**From:** [REDACTED]  
**To:** [Cleve Hill Solar Park](#)  
**Cc:** [REDACTED]  
**Subject:** Cleve Hill Solar Park Project EN0085 re 20018862  
**Date:** 12 June 2019 07:49:56  
**Attachments:** [REDACTED]

## Cleve Hill Solar Park – Soil and agricultural Use Classification– Objections

Cleve Hill Solar Park development engaged Land Research Associates Ltd to conduct a Soil and Agricultural Use and Quality survey at Cleve Hill Farm near Faversham, Kent, the land being proposed as the site for a solar farm development. The report 1294/1 was dated 22<sup>nd</sup> March 2017 (presented in Appendix II) and on-site field work was conducted either in the first or second week March 2017 (which is based on the laboratory report prepared by NRM and sample receipt dated 13/03/2017, presented in Appendix III).

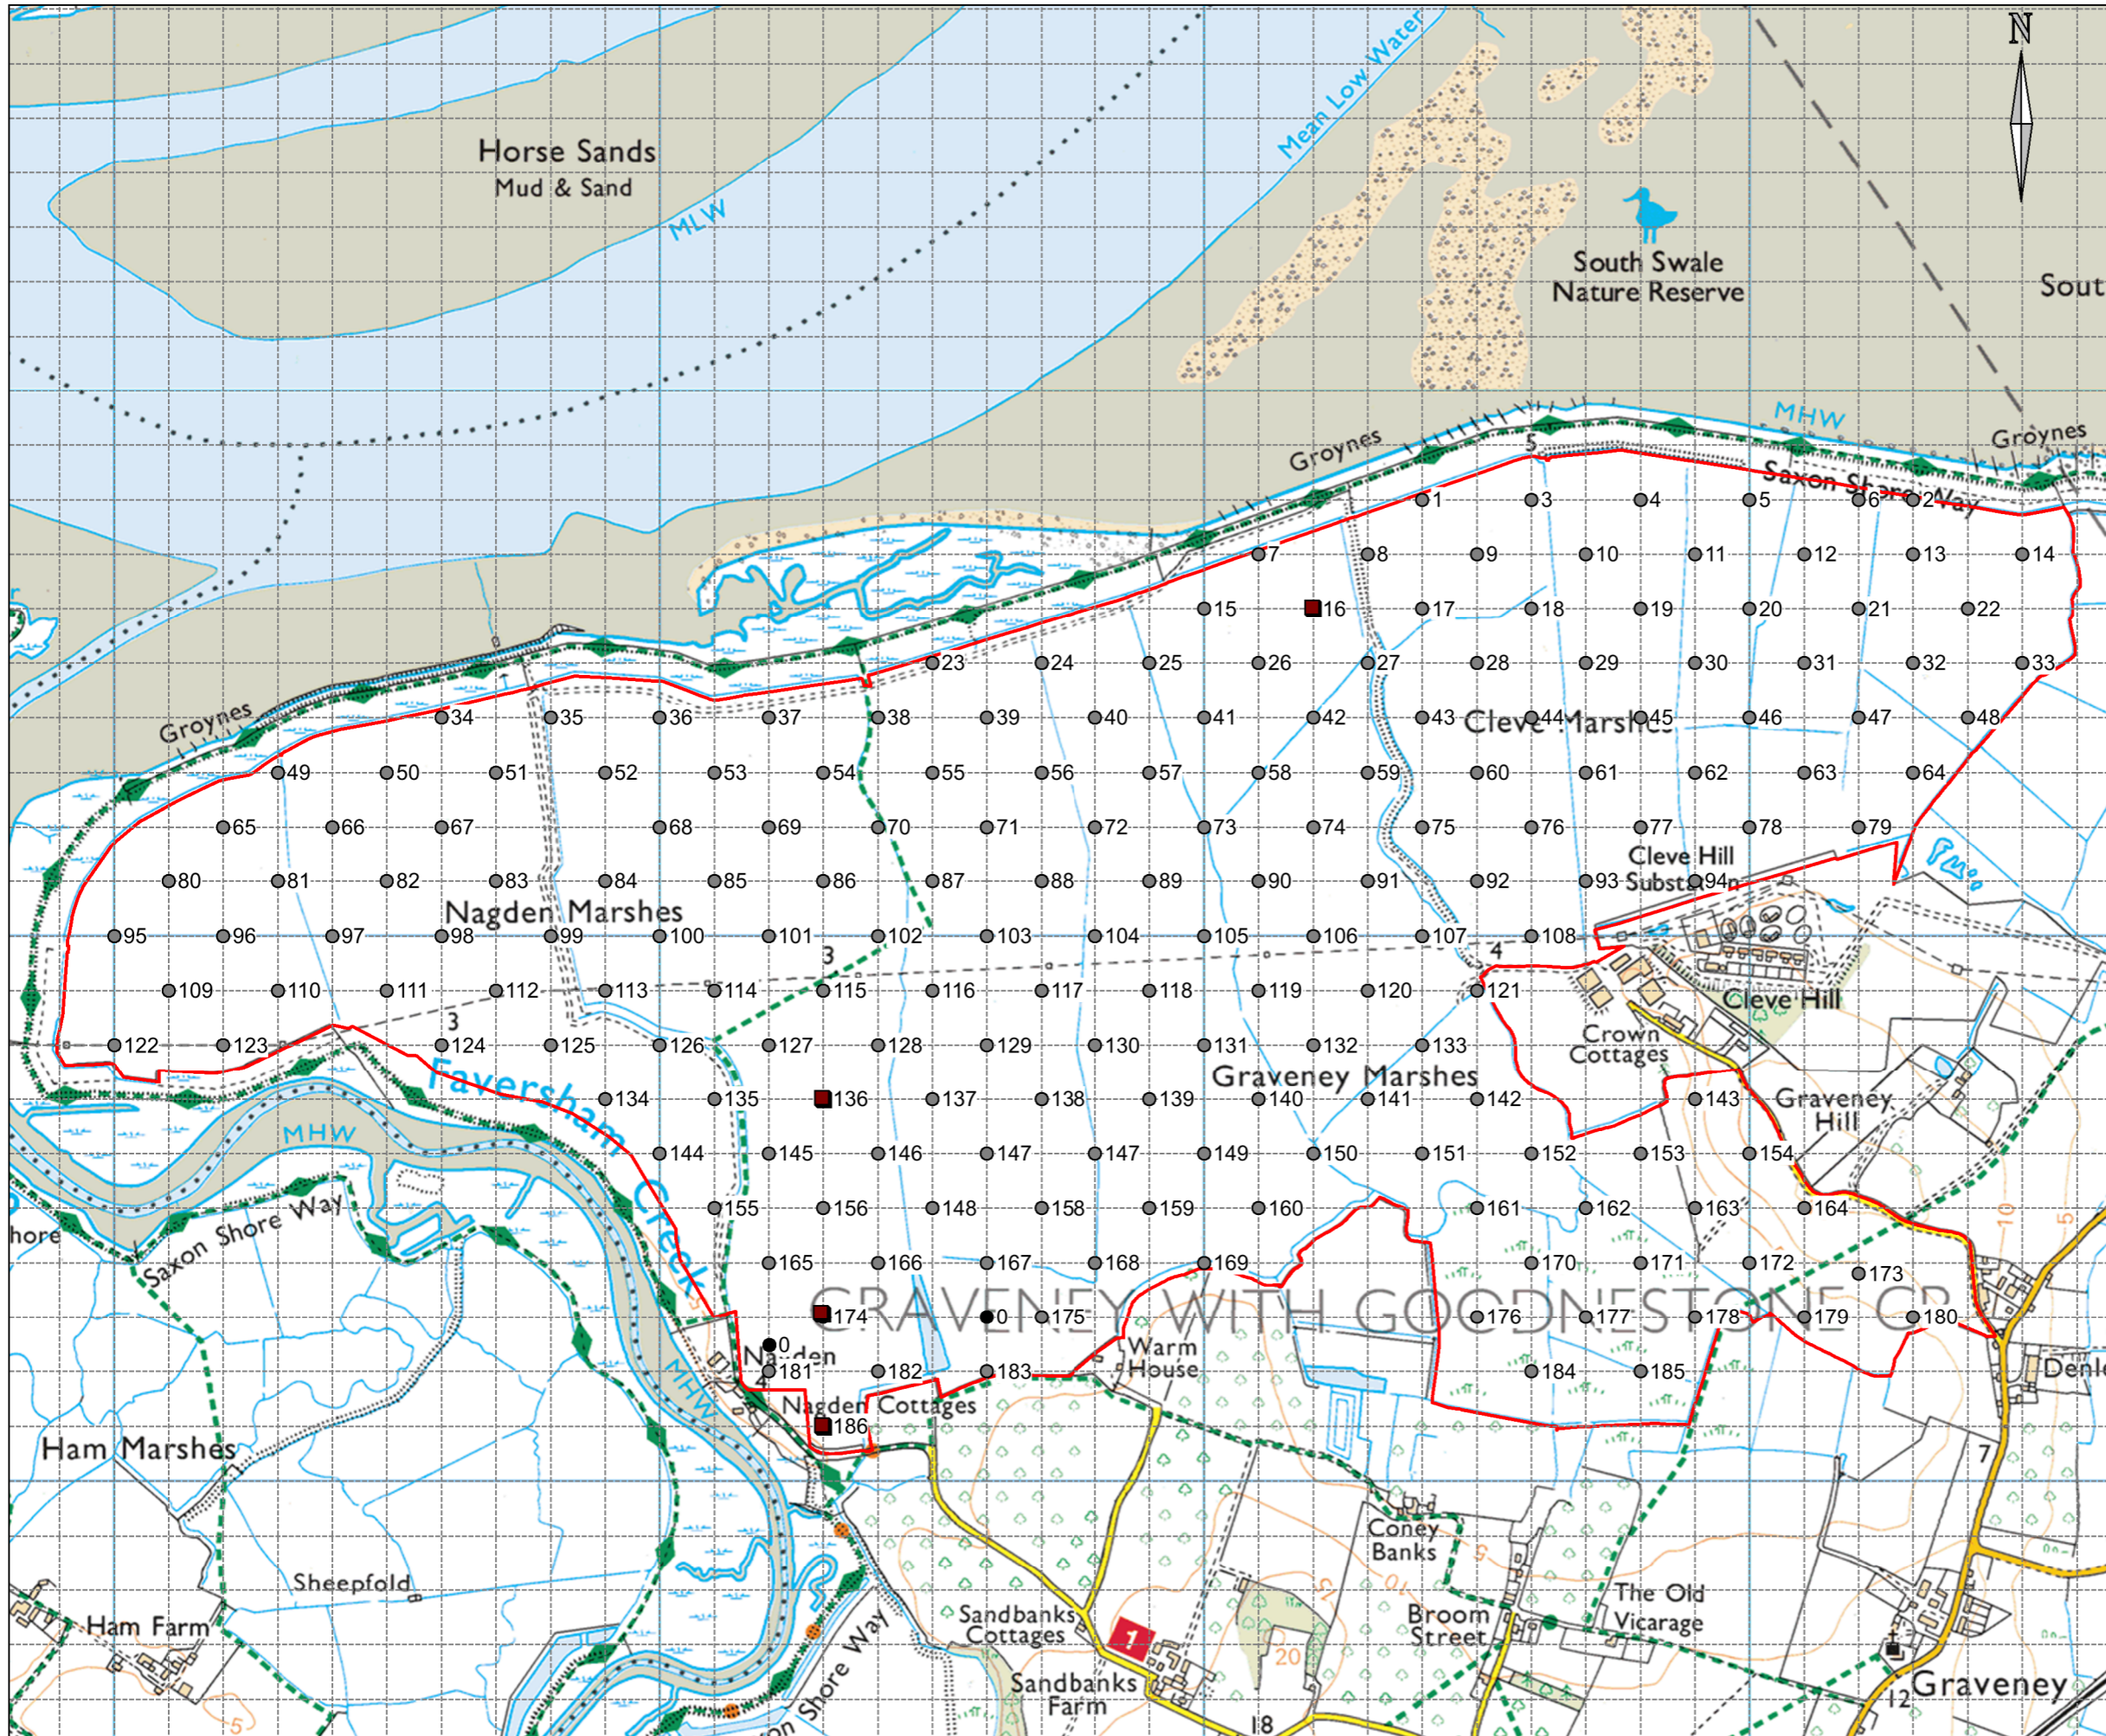
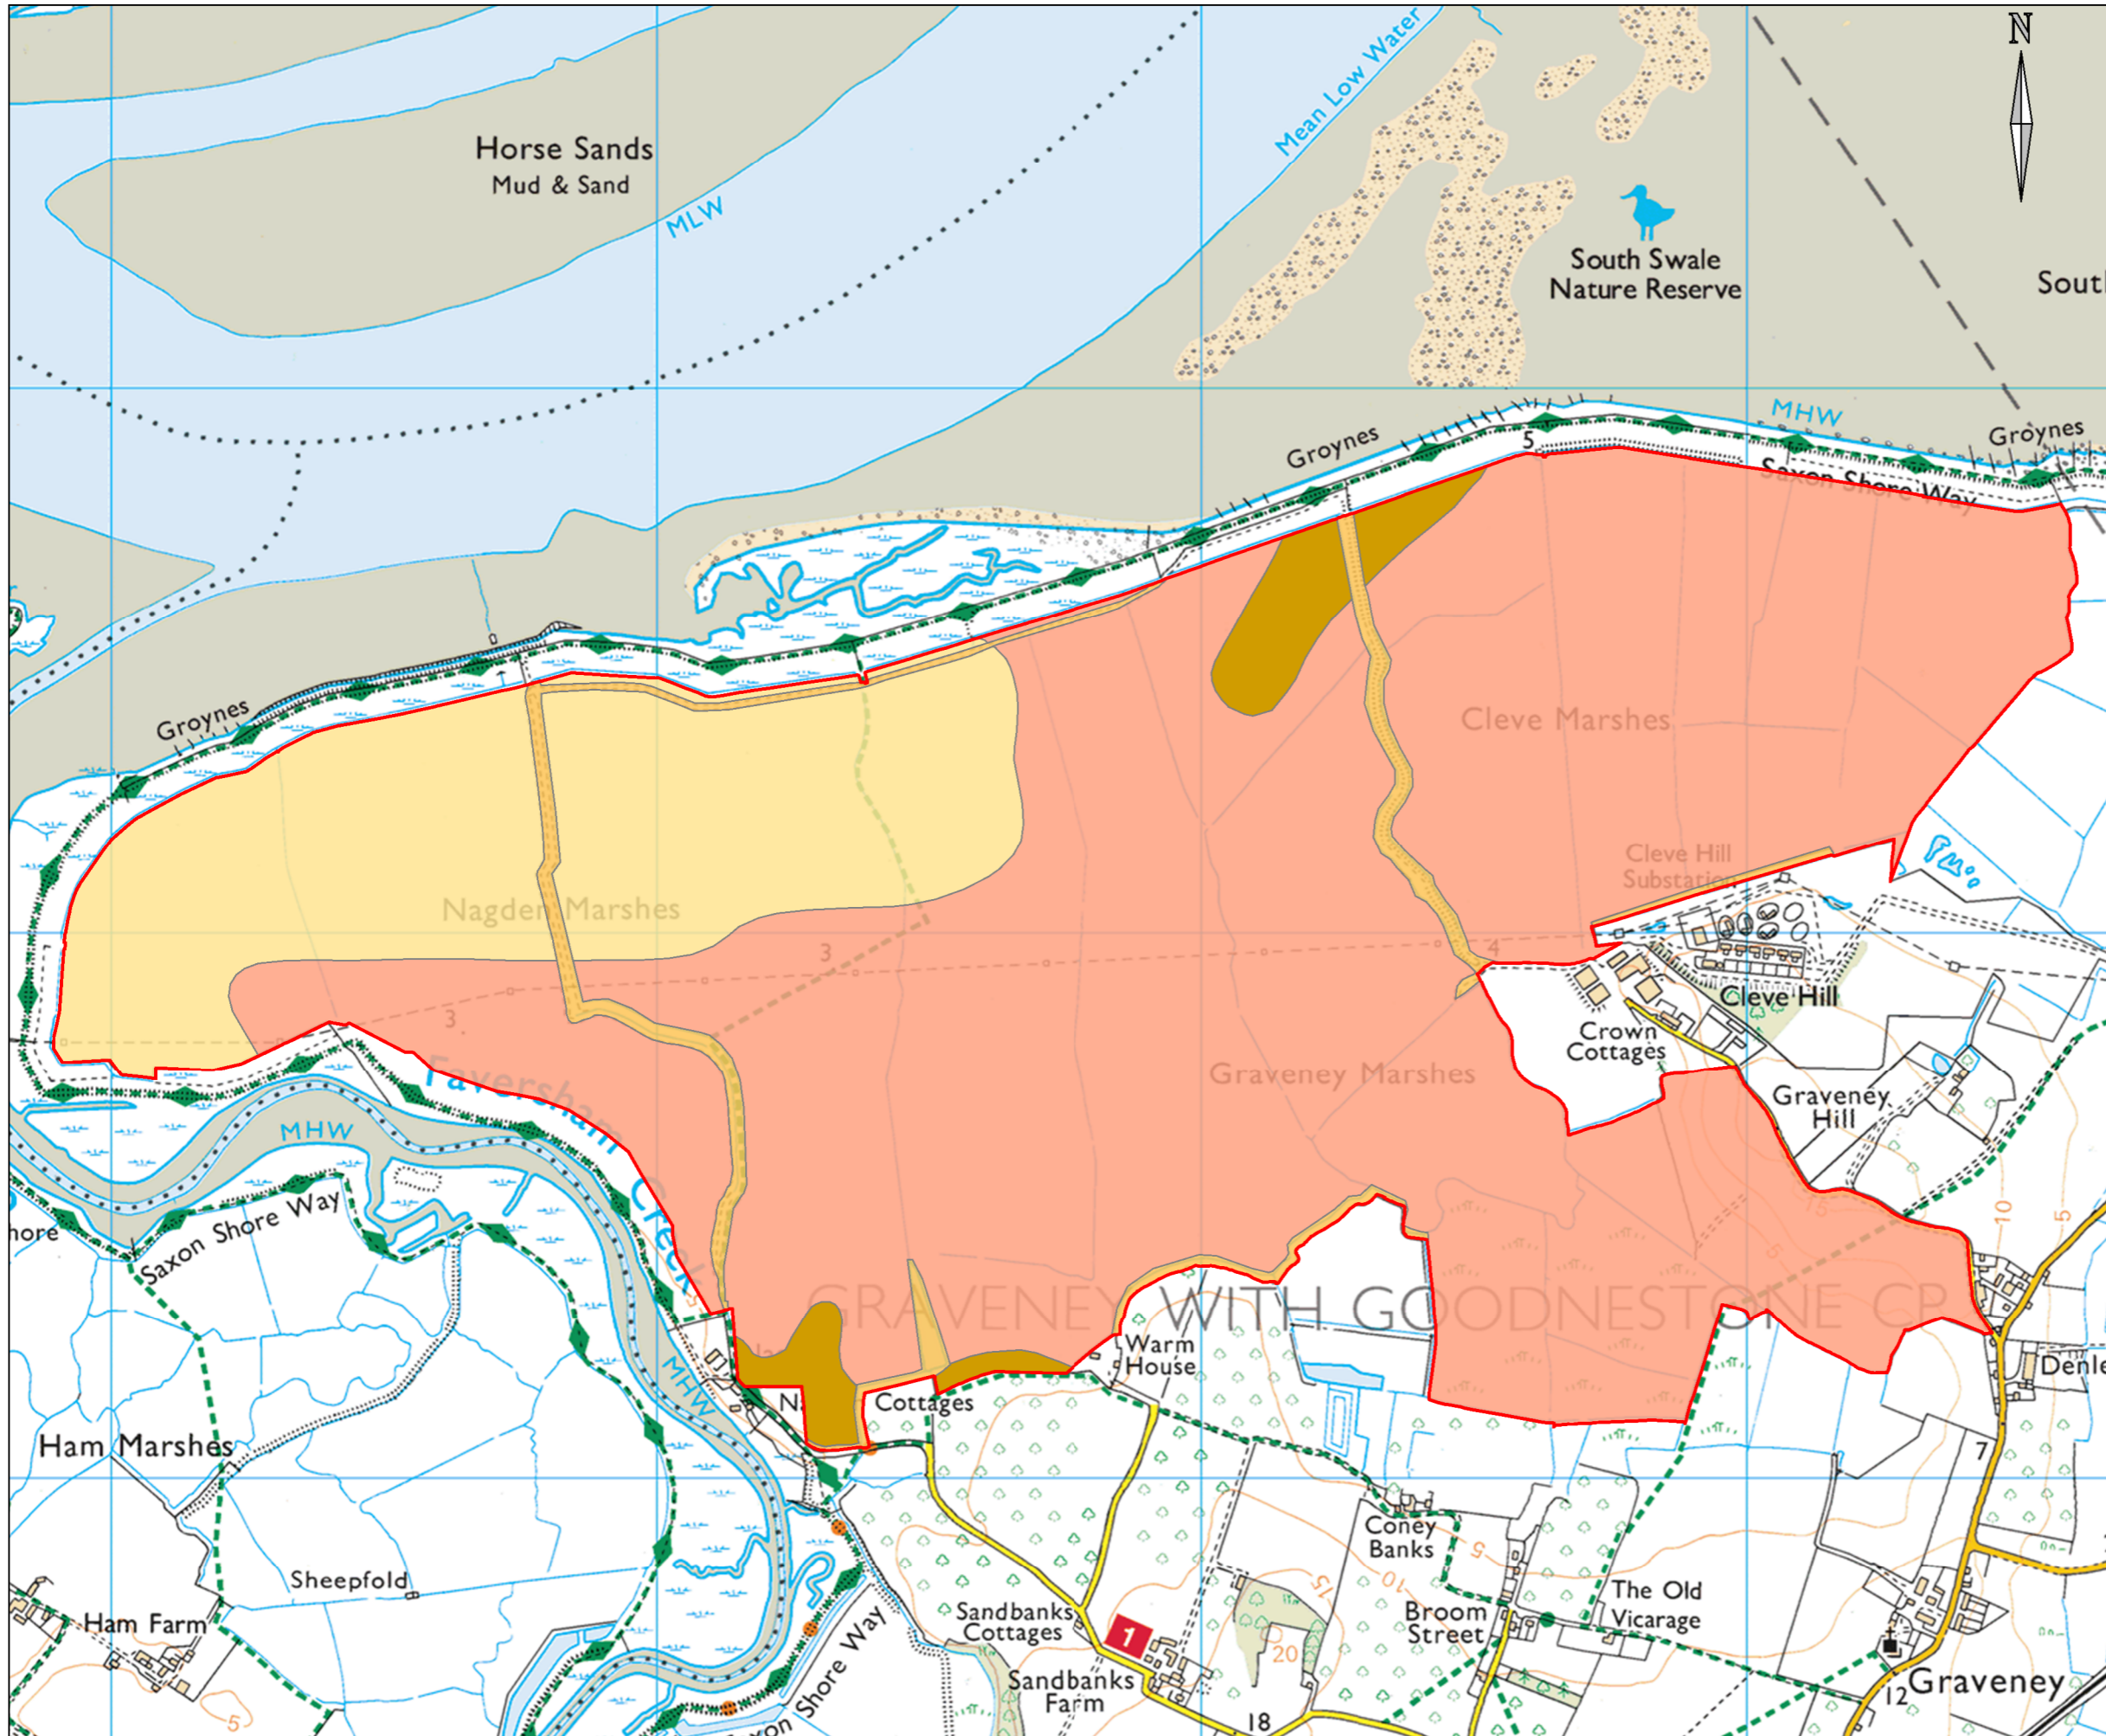
- There are 23 field observations missing within the report for field observation points 123 to 156 and no reason given why this data has been omitted;
- No data is presented for field observation points 27, 67 and 157. Again no explanation was provided why this data has been omitted;
- There are typographical errors in the drawing representing the observation point locations, with number 147 presented twice, and observation point 148 appearing in the incorrect sequence and observation point 158 not presented in the drawing;
- No compass rose presenting North;
- The majority of the field observation points do not reach target depth of 120cm as detailed in the ALC MAFF 1988 guideline.

However, in the case of observation numbers 35, 37 and 54 these locations should be compared to Figure 8, as no gleying or mottling has been observed within the first 40cm. These three sample locations, comprising approximately 6 ha, were incorrectly graded in the Cleve Hill Solar Park SALUQ 2017 report, as the field observation should have been compared to Figure 8 of the MAFF 1988 guideline.

Furthermore, In the case of the observation point descriptions presented in the Cleve Hill Solar Park SALUQ 2017 report, and based on the local metrological data detailed above, the following additional observation points have been re-assessed considering a Wetness Class II, that the clay soils in case of 12, 20, 30, 46, 62, 73, 74, 78, 90, 91, 94, 103, 106, 107, 109, 110, 111, 112, 113, 114, 116, 119, 120, 121, 161, 162, 163, 165, 167, 170, 171, 173, 176, 177, 180, 184 and 185 are identified as Subgrade 3a soil based on the Field Capacity Days and soil texture of the top 25cm.

Additionally, the silty soils (abbreviated as SC) at observation locations 3, 4, 6, 9a, 10, 13, 14, 17, 20, 21, 22, 24, 28, 29, 31, 33, 40, 41, 42, 43, 44, 45, 47, 48, 57, 58, 60, 61, 63, 64, 72, 75, 76, 77, 79, 88, 89, 92, 93, 104, 105, 117, 118, 158, 159, 164, 166, 168, 169, 172, 174, 175, 179 and 108, can be classified as Subgrade 3a using the same approach detailed above.

Paragraph 3.9 of the Cleve Hill Solar Park SALUQ 2017 report details that 'in small areas in the south east around Cleve Hill, the land slopes at between 7 and 11 degrees' and that 'gradient is therefore an equally limiting factor on this land'. However, this statement is not corroborated with any data. Based on data presented in Appendix of the Cleve Hill Solar Park SALUQ 2017 report, details of observations at each sampling point, detailing 186 observation points, the steepest slopes reported were 6° at sample location 164, 5° at location 174 and 4° at location 180.
